From: Harold Parr [REDACTED]
Sent: 19 July 2018 16:36
To: Zac Denton
Subject: RE: LU/124/18/DOC

Cc: Juan Baeza
Subject: LU/124/18/DOC

Following consultation with our Environmental Health department, the LPA is considering the following restriction:

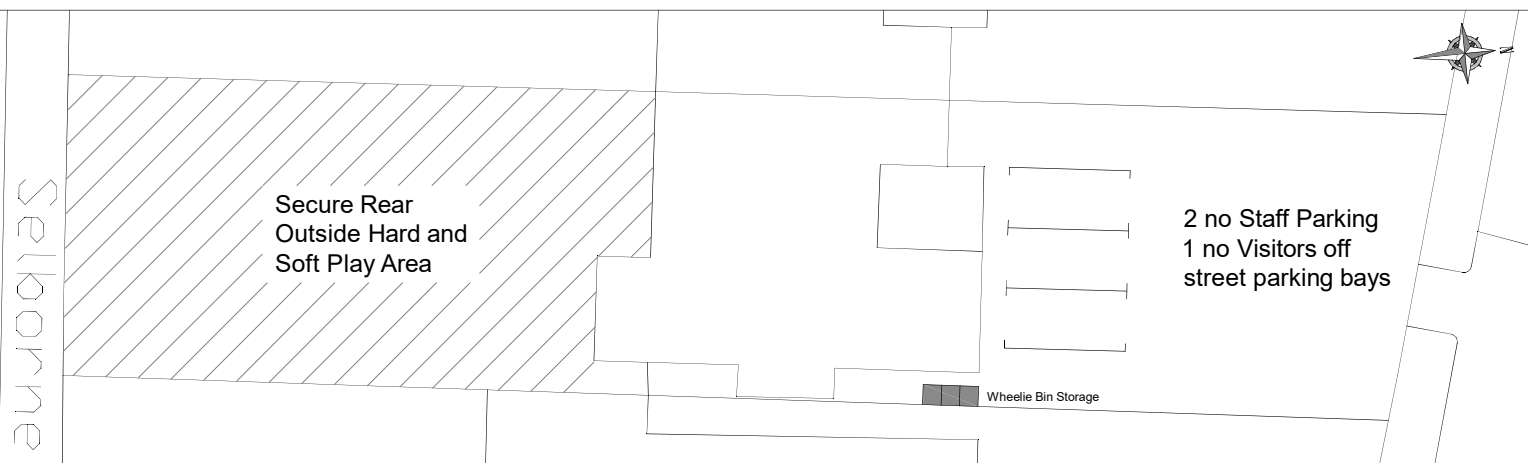
“Testing to be carried out by the noise consultant and reported to this Department within one month of operation of the facility at maximum capacity or thereabouts, to ensure that the Management System is being adhered to and that sound insulation provided to party walls is effective. The Layout of the premises to accord with Page 2, Paragraph 2.8 (quieter rooms against the party walls).”

Further to your email below, my client has informed me they accept the restrictions regarding use of the external play area and the required tests will be carried out according to requirements within the timescales stated.
